**Harnett County**  
420 McKinney Pkwy

**SUBJECT: SFD2208-0051**  
**SINGLE FAMILY DWELLING**

Here are the results of all Inspections located at **507 S LINCOLN ST:**

SHEET NAME
 FOUNDATION
 SHEET #
 A3 of 6

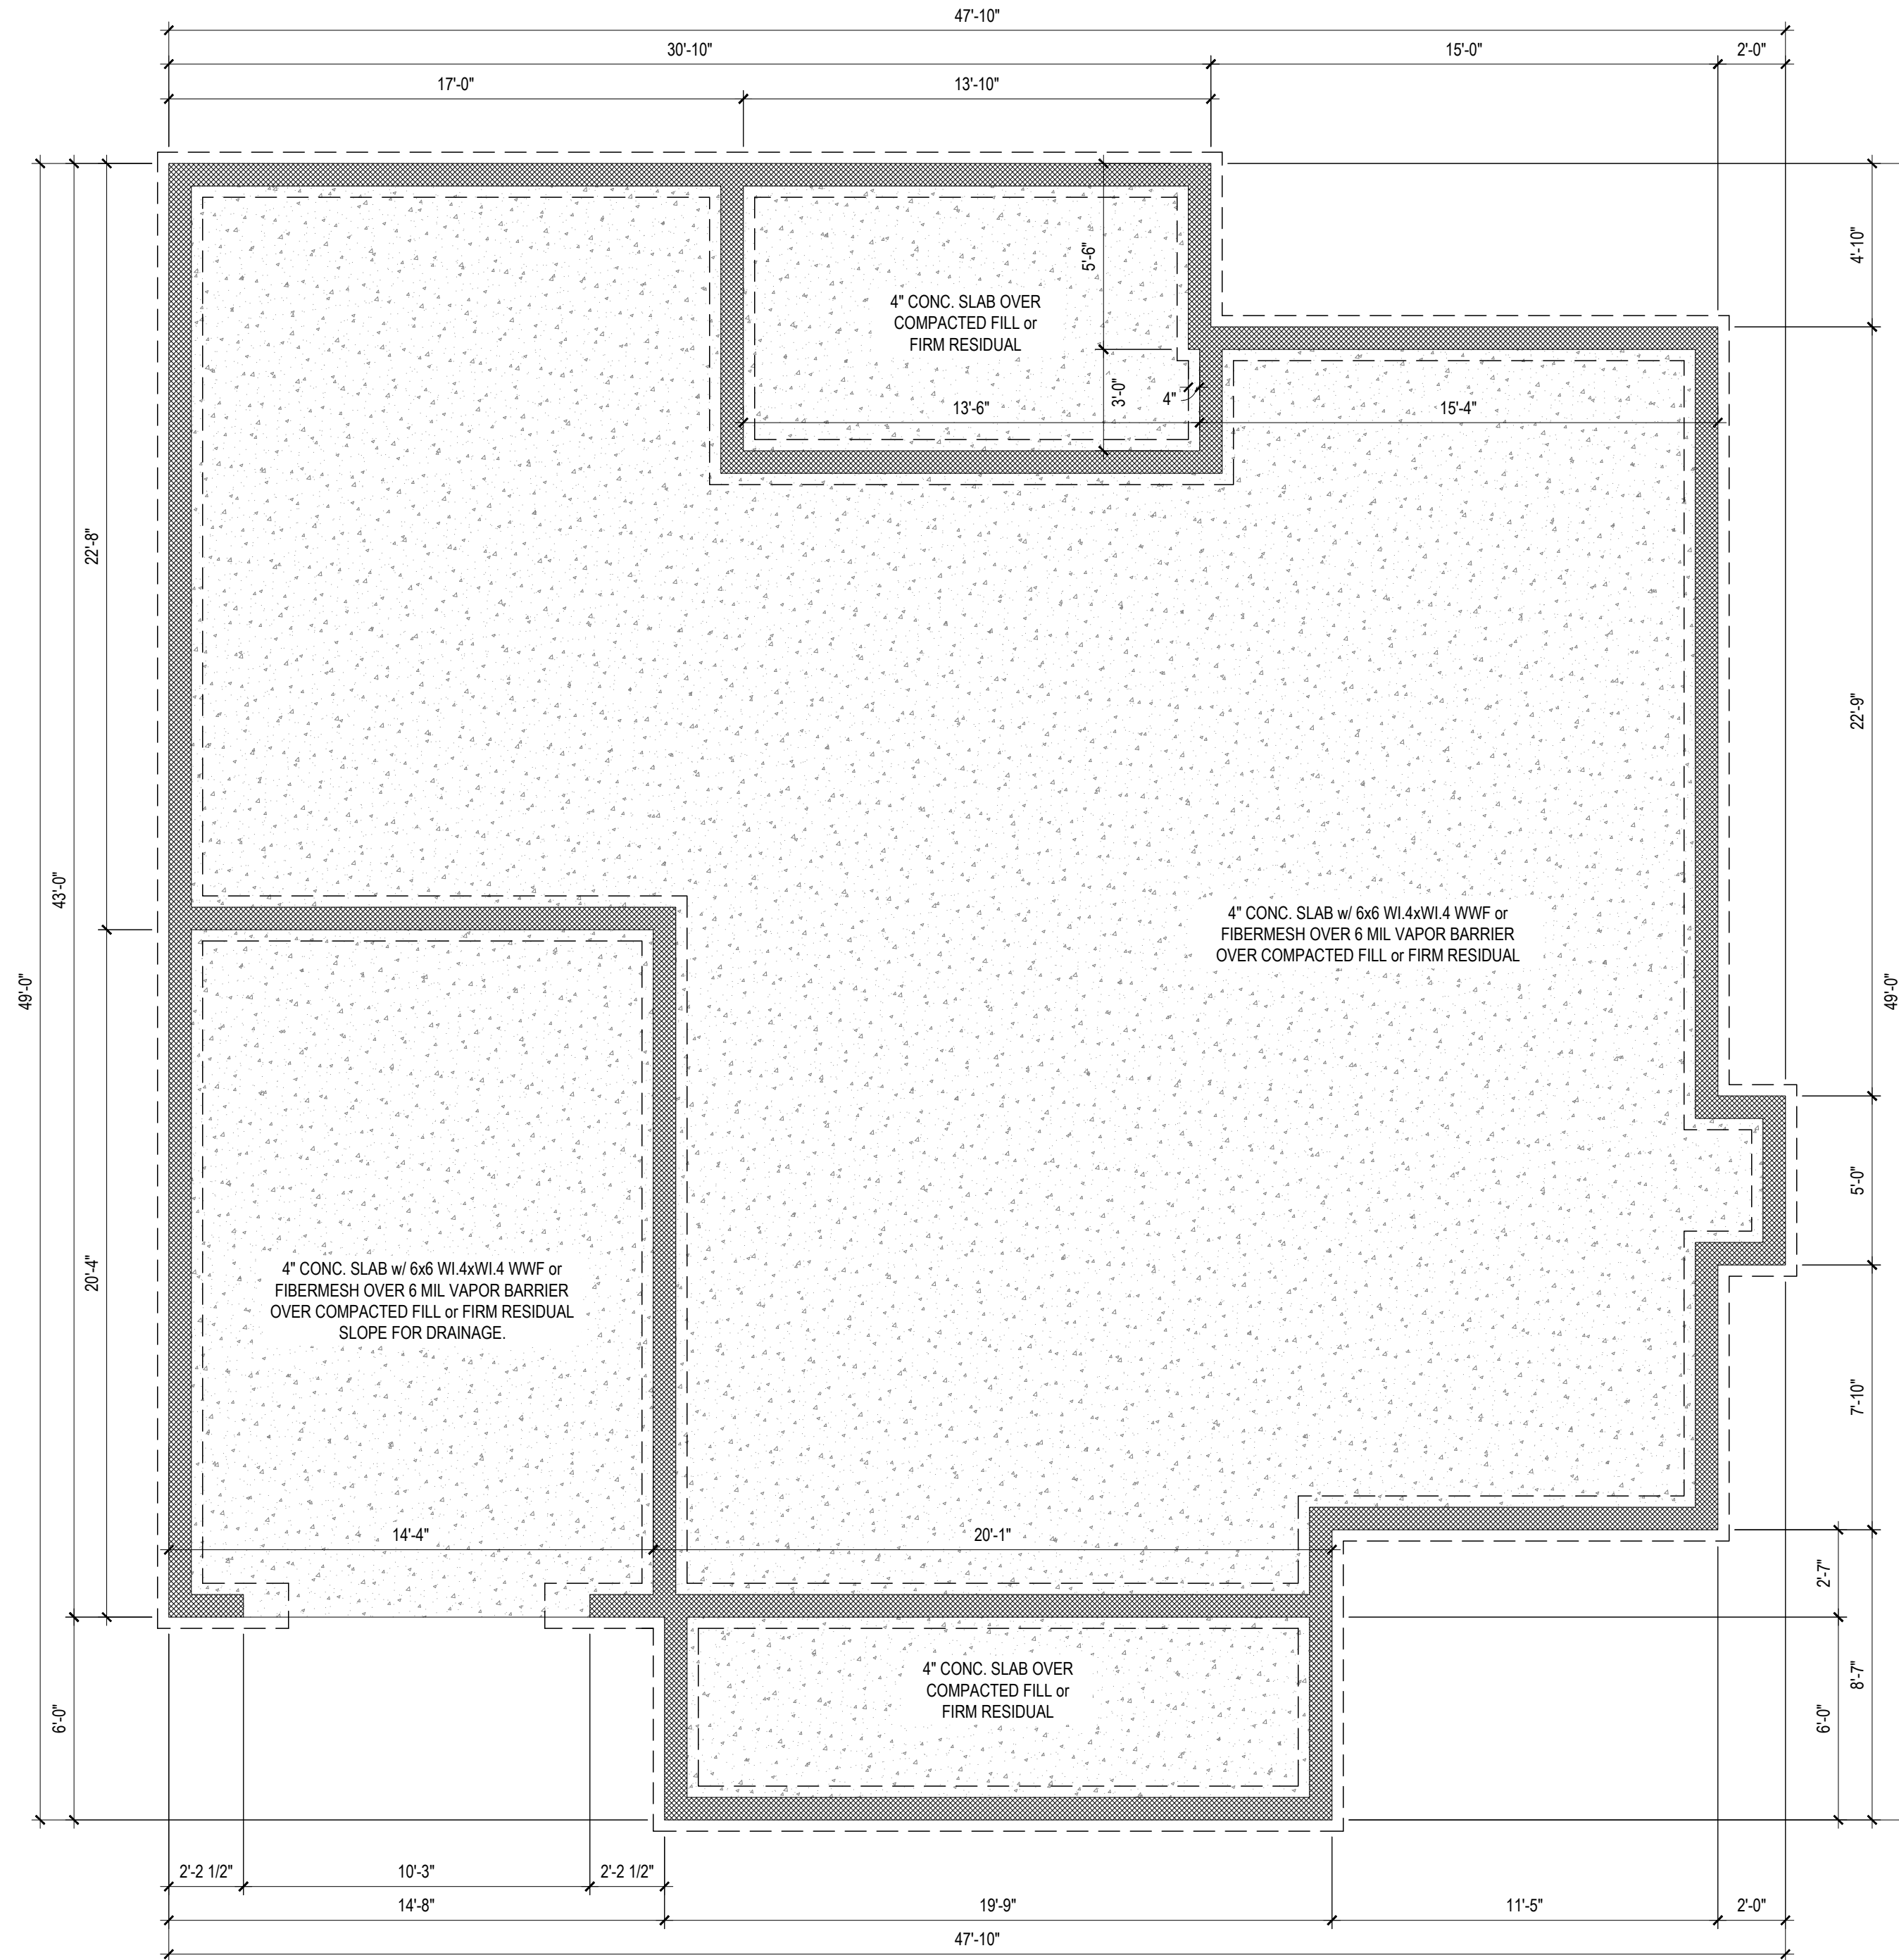
Must have 4 inch clearance from foundation vents to grade. Could not locate energy efficiency certificate. Pull down stairs have gaps at joints when extended, must be cut to correct lengths per manufacturers instructions. Barn door in hallway encroaches on required egress, Hall must be minimum 36 inches wide

SHEET NAME
1ST_FLOOR
SHEET #

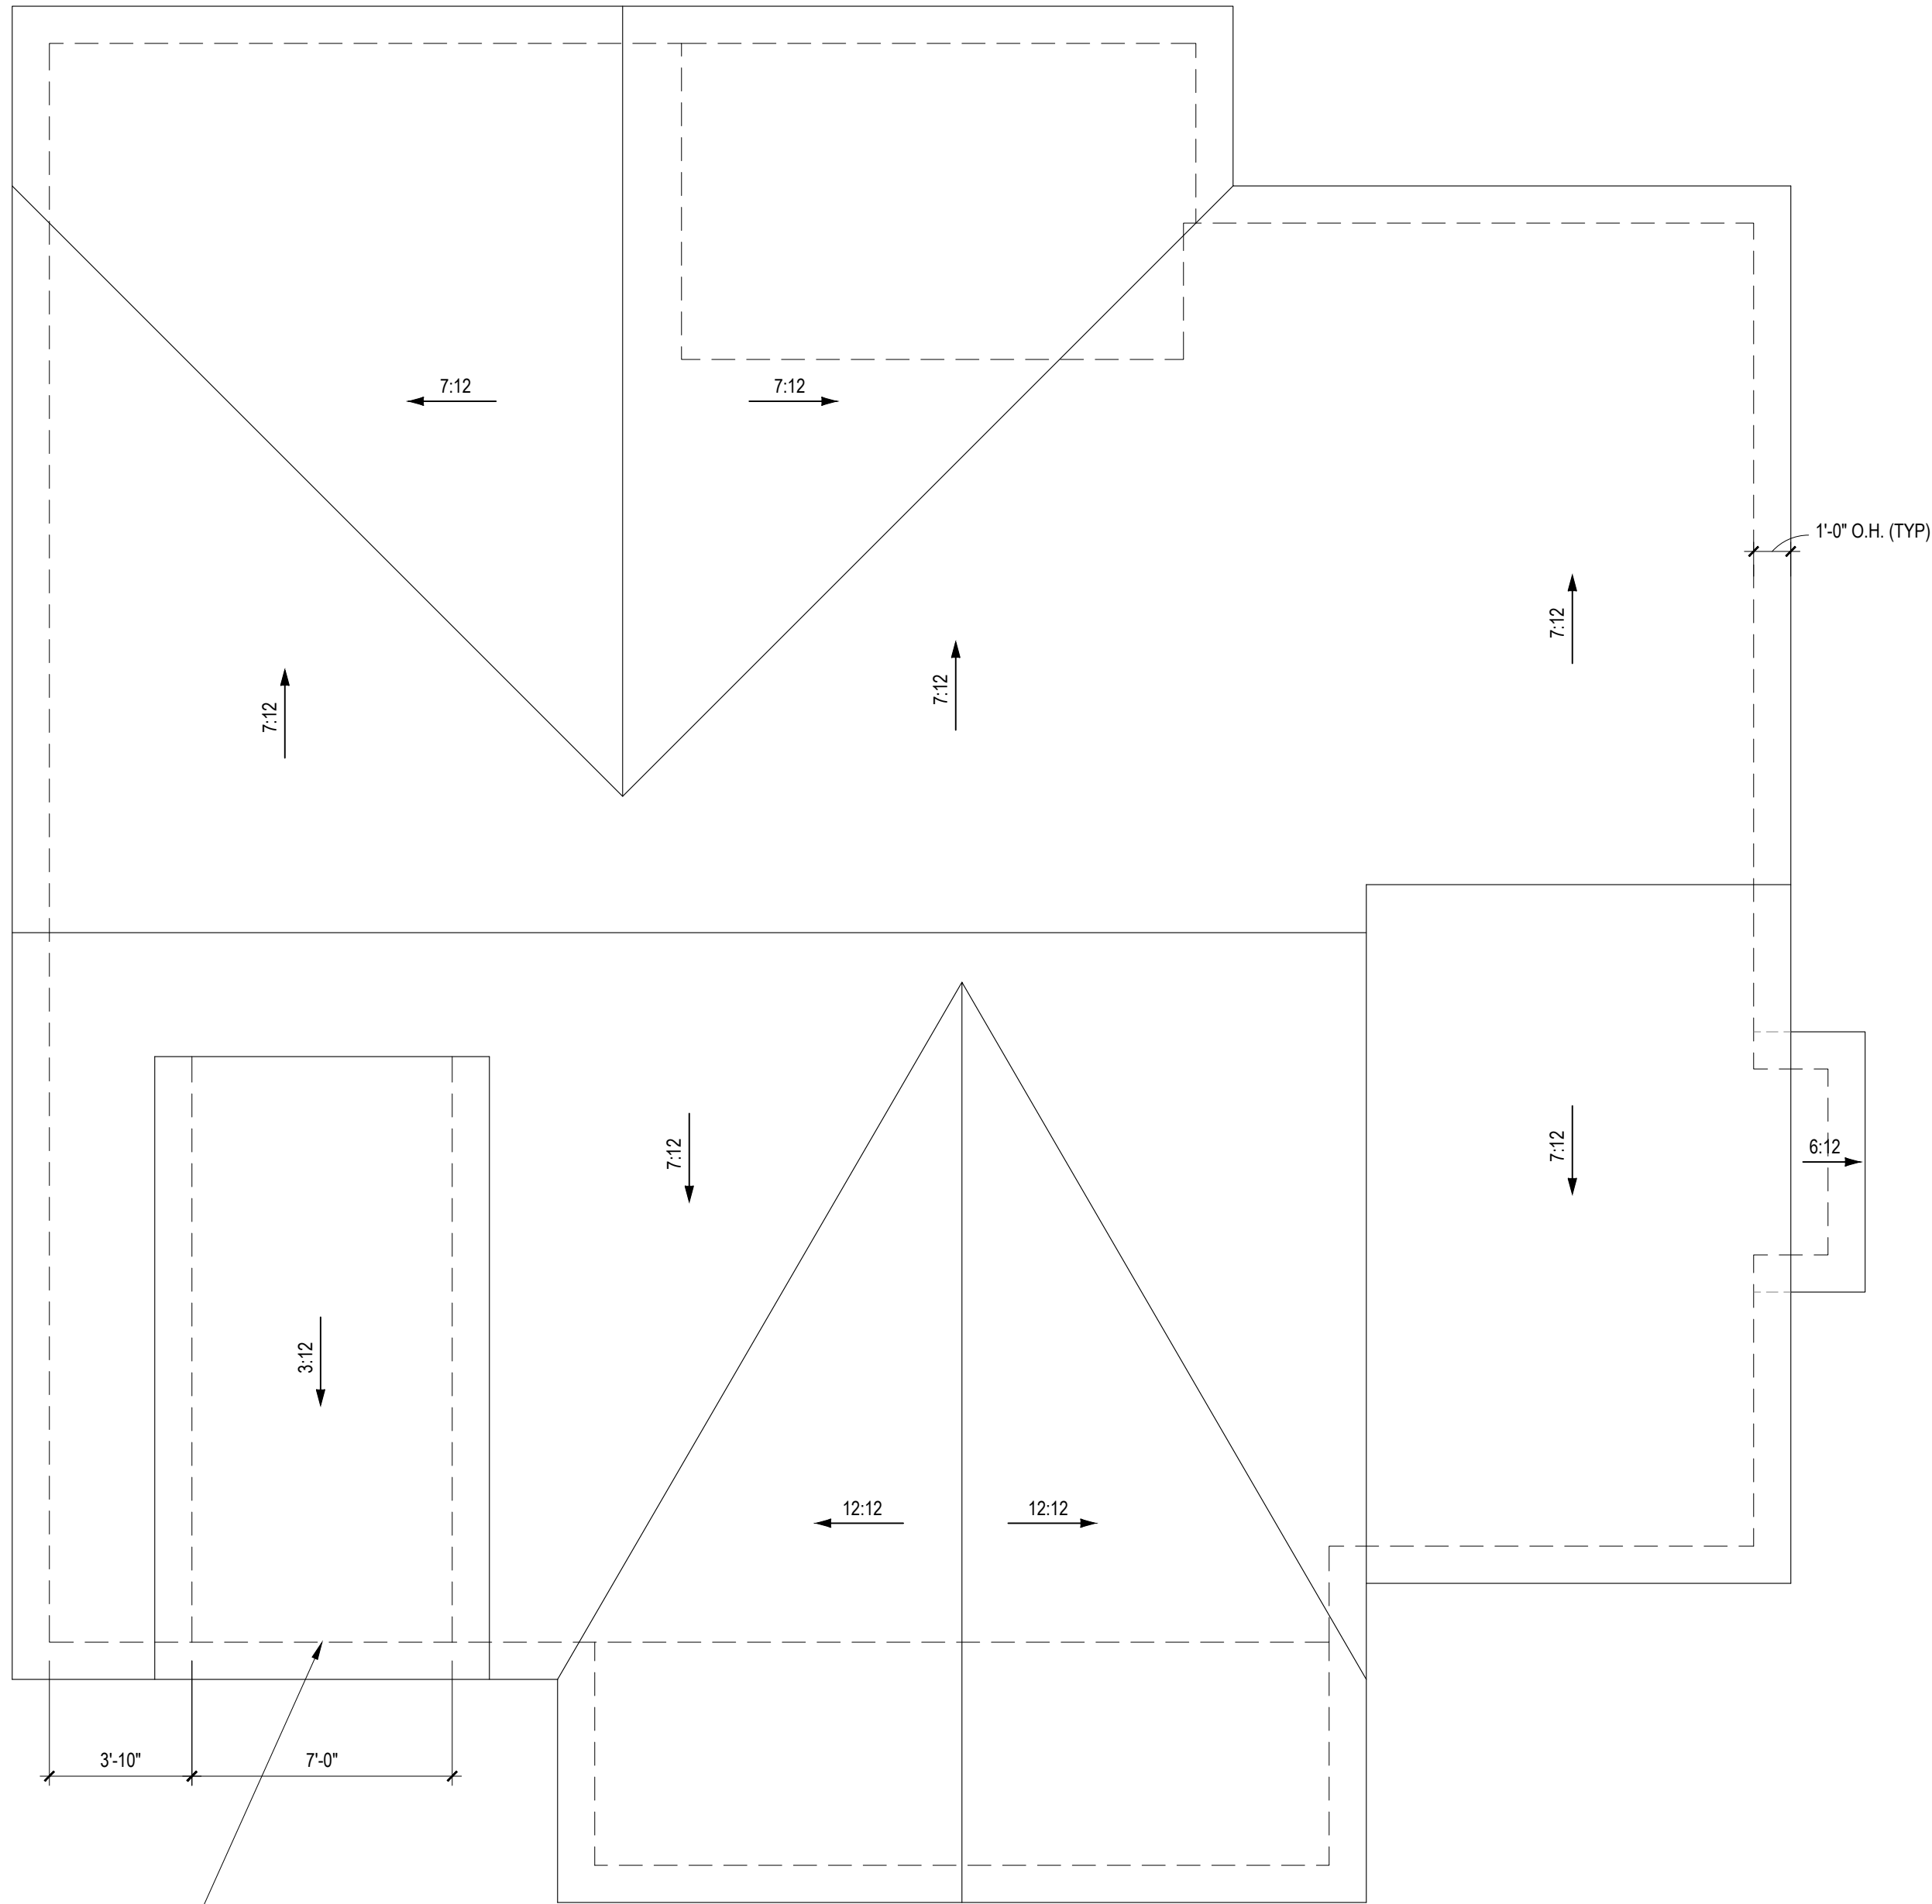
Need 3 feet of water in standpipe for drain test. Window above master bath tub and outside of shower must be tempered. OK to insulate

Inspection Type: INSULATION  
Scheduled Date/Time: 11/17/2022  
Completed Date/Time: 11/17/2022  
Inspector: Deen Taylor  
Result: APPROVED  
Remarks: eTRAKiT Inspection Request  
Notes: 11/16/2022 9:58 AM Pleasant Builders of NC LLC  
I have ordered tempered glass replacement for the window over tub. There will NOT be Shower doors for the stand up shower in Master bath. Let me know if that means the window beside shower will pass inspection without being tempered glass. Thank you!  
Contact Name: Pleasant Builders of NC LLC  
Site Address: 507 S LINCOLN ST  
Phone: 9198787685  
e-Mail: pleasantbuildersnc@gmail.com
